OBSERVATION/SUBMISSION TO PLANNING APPLICATION

Case Reference: 324113

Re: Observation to the proposed development of open-cycle gas turbine (OCGT) and generator with ancillary equipment.

Location: Pollnagroagh and Rathmorrissy (Townlands), Athenry, Co. Galway

Purpose		PLANNING			
Title		SITE ACCESS SIGHTLINES			
Original Scale	Design/Drawn	Checked	Authorised		
SHOWN at A1	PS	ND	AJB		
Date	Date	Date	Date		
01.12.25	01.12.25	01.12.25	01.12.25		
Status	Drawing Number	Rev			
A2	PEK3-ATK-ZZ-01-DR-CE-901200	0

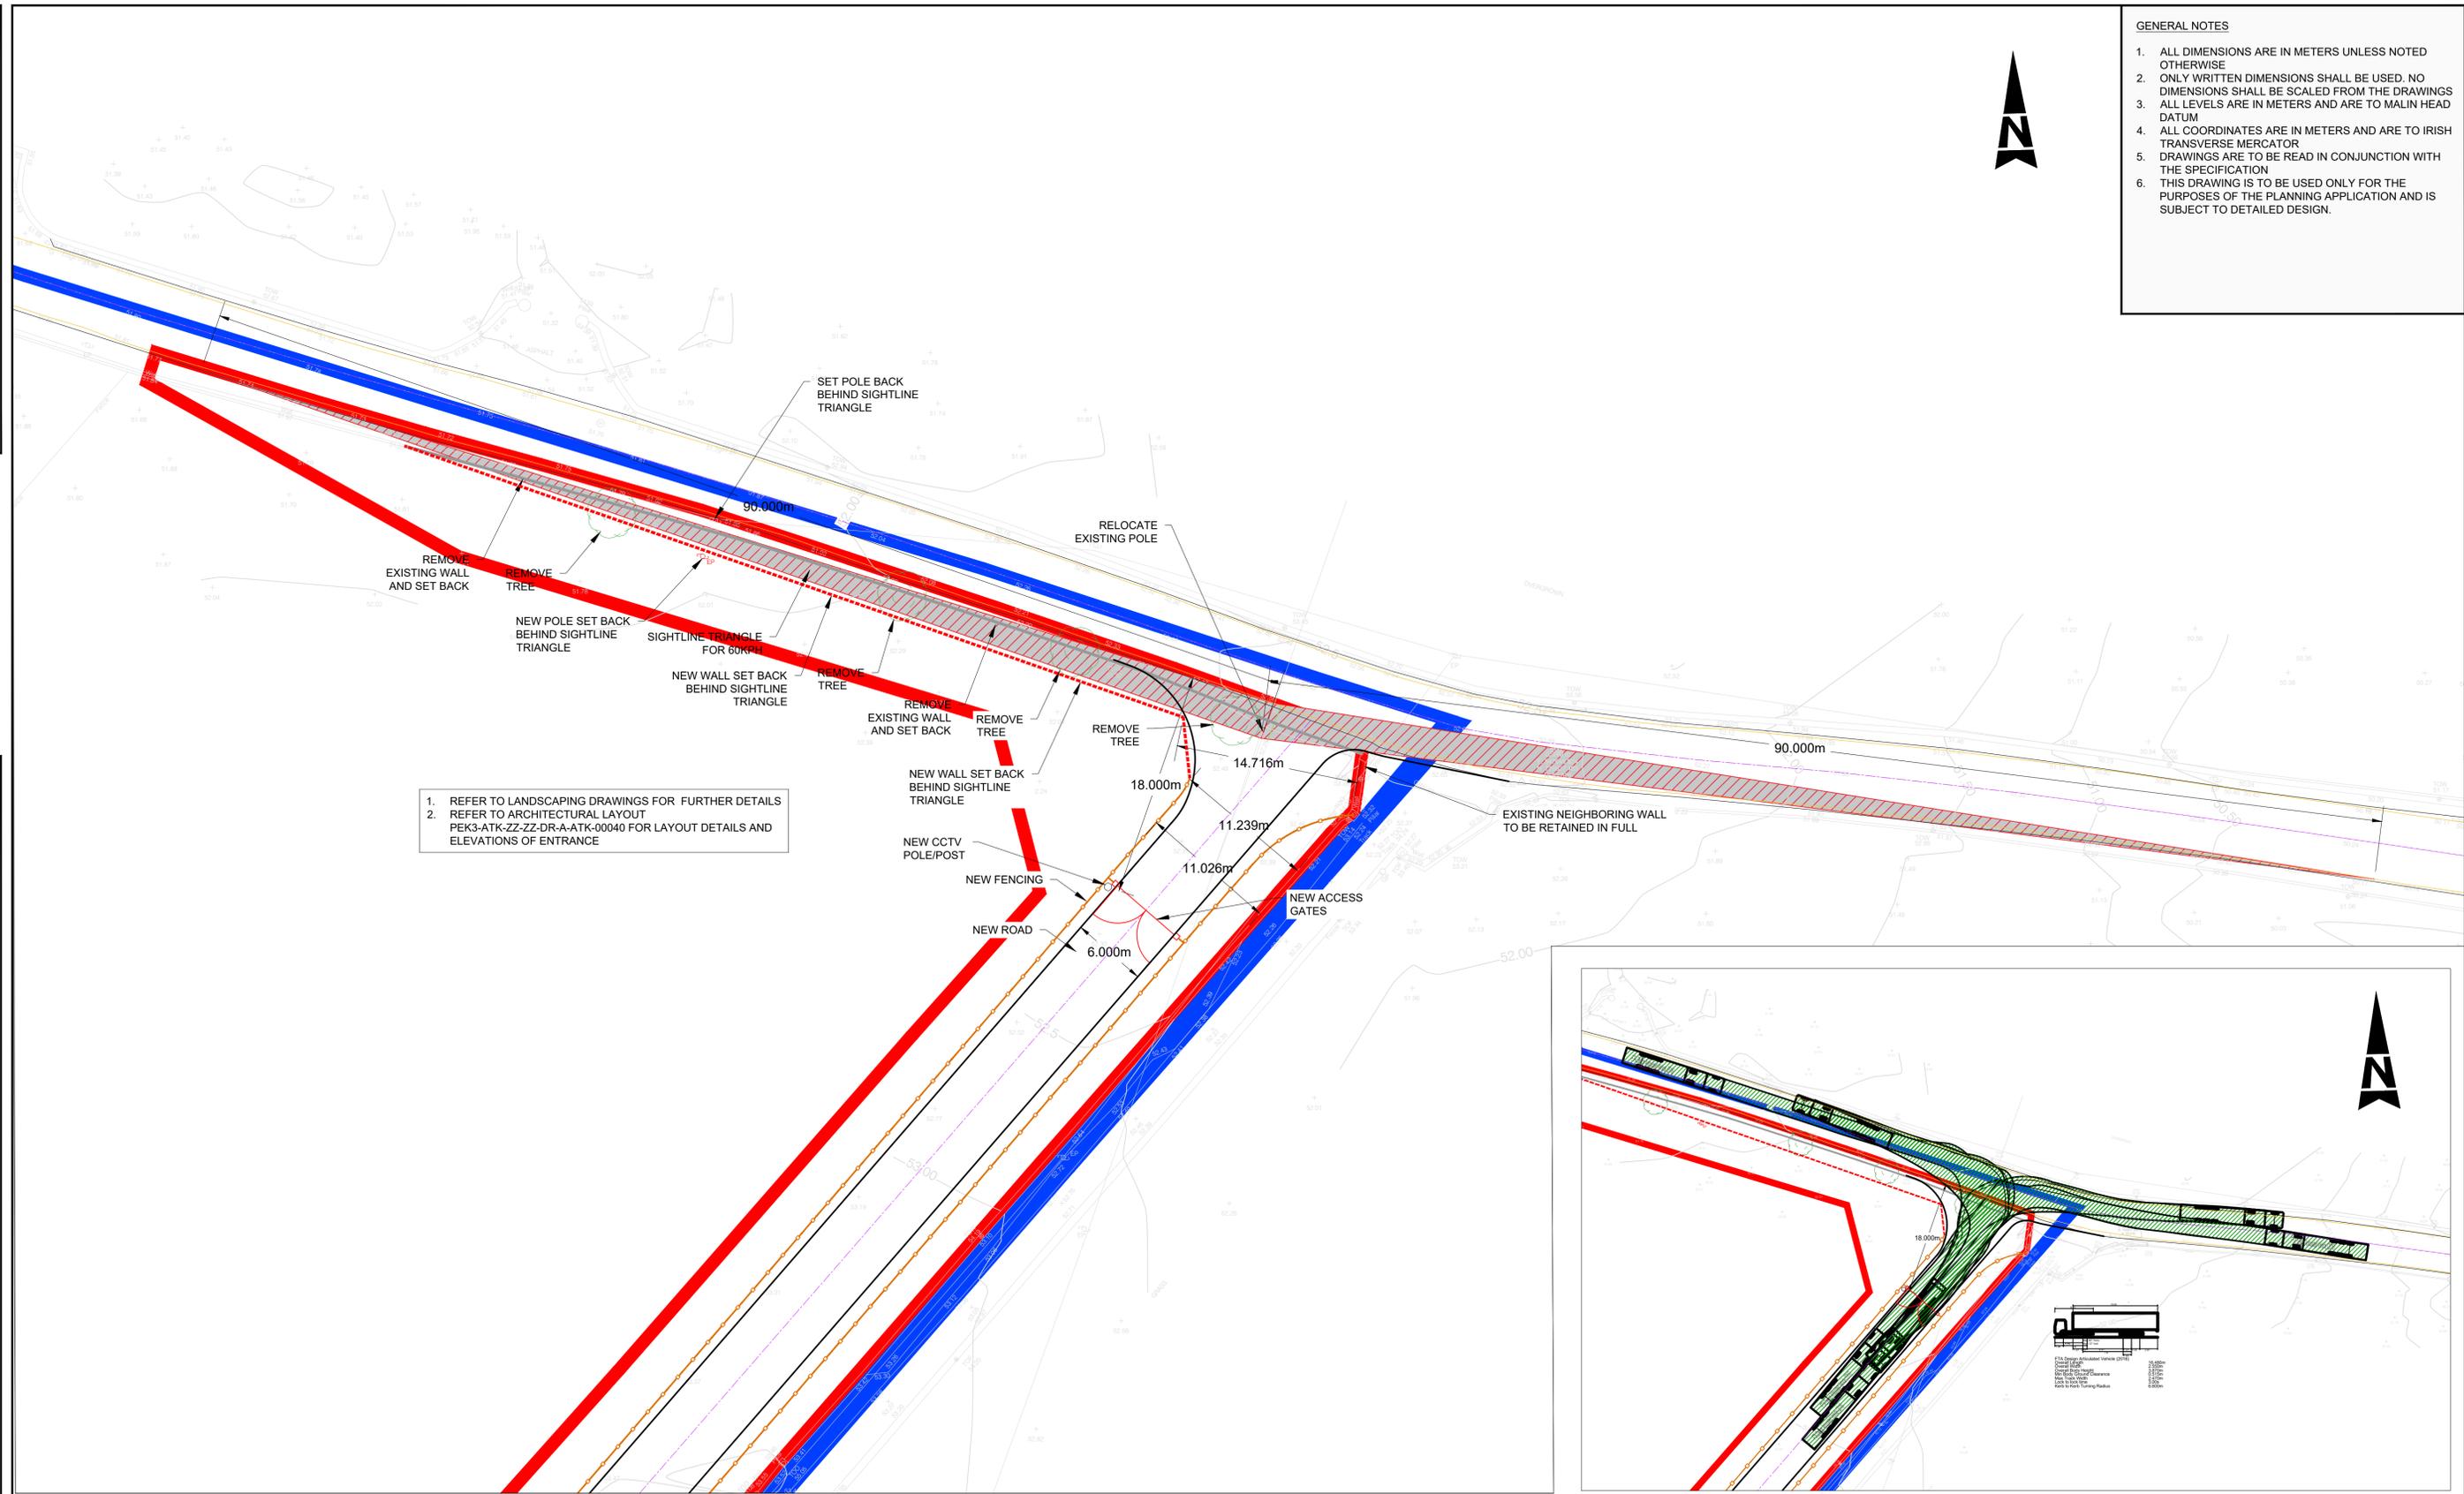
As someone who lives locally and extensively uses this road, I am concerned about the proposed location of the site entrance on the L3103. This section of road is already extremely dangerous, as it is narrow, has no hard shoulder, and does not provide sufficient space for two heavy goods vehicles to pass safely. Visibility is also poor due to blind dips and sharp bends, meaning drivers often cannot see oncoming traffic in time, and introducing a site entrance at this location would significantly increase the risk to all road users.

There are strong concerns that adding traffic—particularly large vehicles—would worsen these existing hazards, especially near homes and schools during busy periods such as morning and afternoon times. The interaction between heavy goods vehicles, farm machinery, and everyday local traffic creates a higher risk of accidents, particularly for children and other vulnerable road users. Overall, this is not a suitable location for this level of traffic, and the associated safety risks for the community are a critical concern.
